From: David Easton
Sent: 06 November 2017 09:22
To: Karen Parsons
Cc: Nicola Spencer
Subject: FW: A/117/17/HH - 49 Ashurst Way

From: David Easton <David.Easton@arun.gov.uk>
Date: 02/11/2017 14:16 (GMT+00:00)
To: [REDACTED]
Subject: A/117/17/HH - 49 Ashurst Way

Proposed floor plan

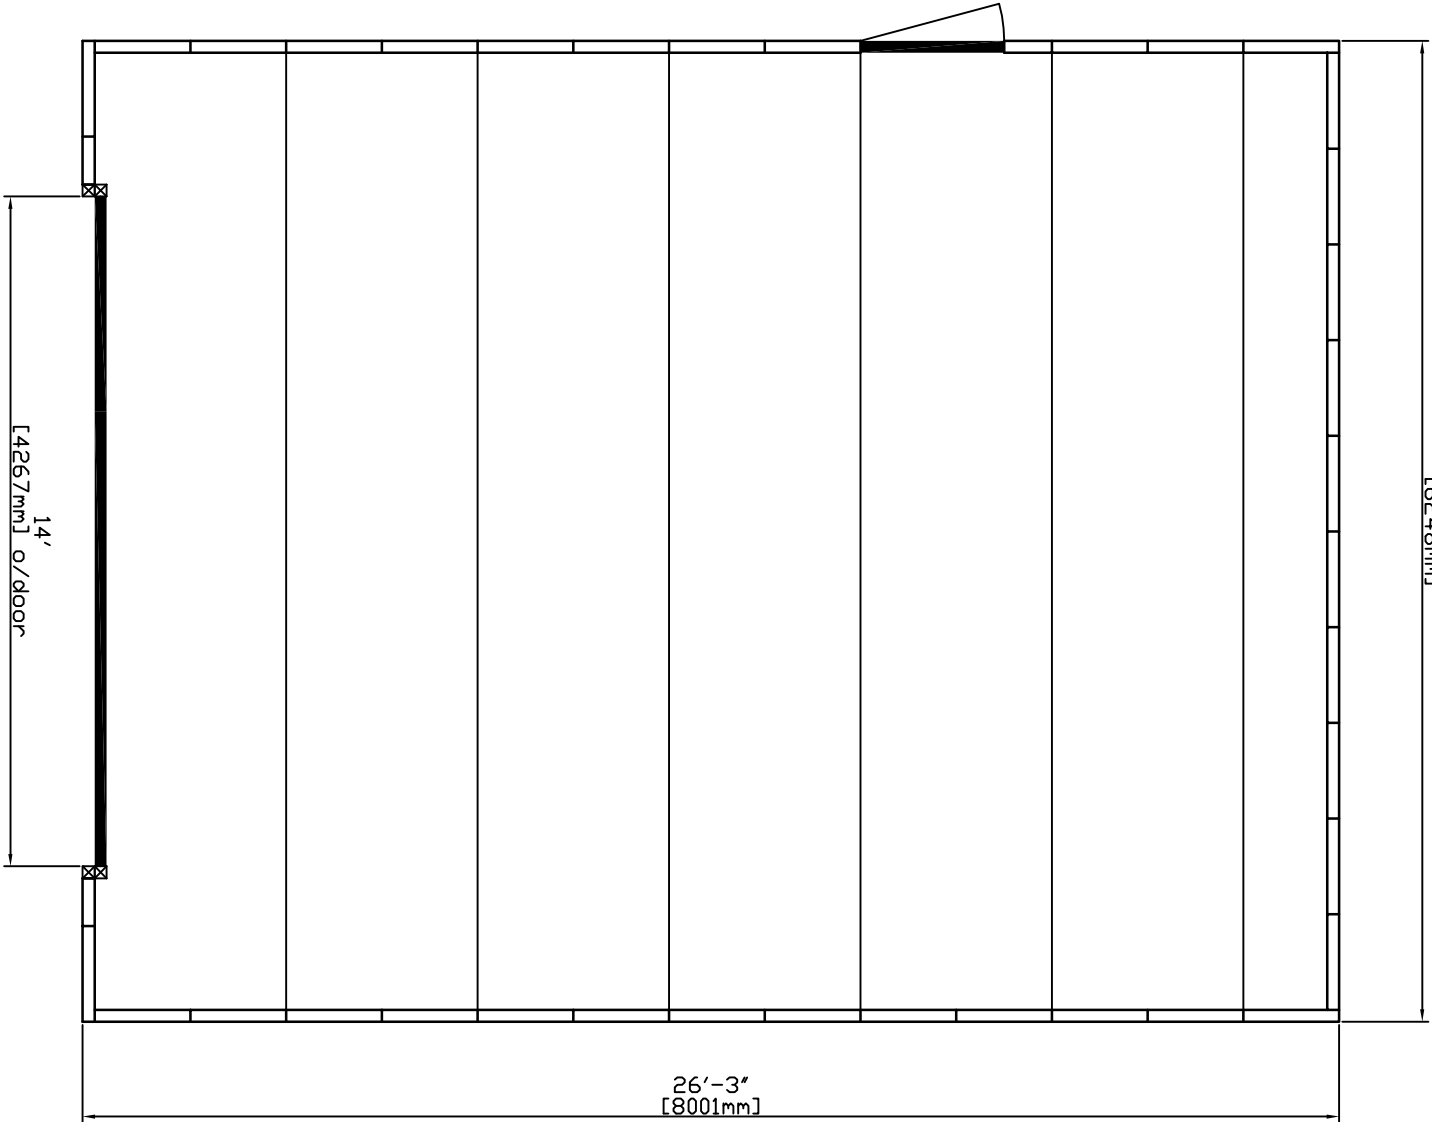
I have now had the opportunity to discuss the above planning application with my team leader in relation to the proposed garage and it is considered that by virtue of its size the proposed garage would have an adverse impact upon the character of the area as well as the host dwelling in conflict with policy GEN7(ii) of the Arun District Local Plan.

Therefore, it has been determined that in this case the proposed garage will either need to be reduced in depth to a maximum of 6m or detailed justification as to why the garage would need to be this size will need to be provided to support the application.
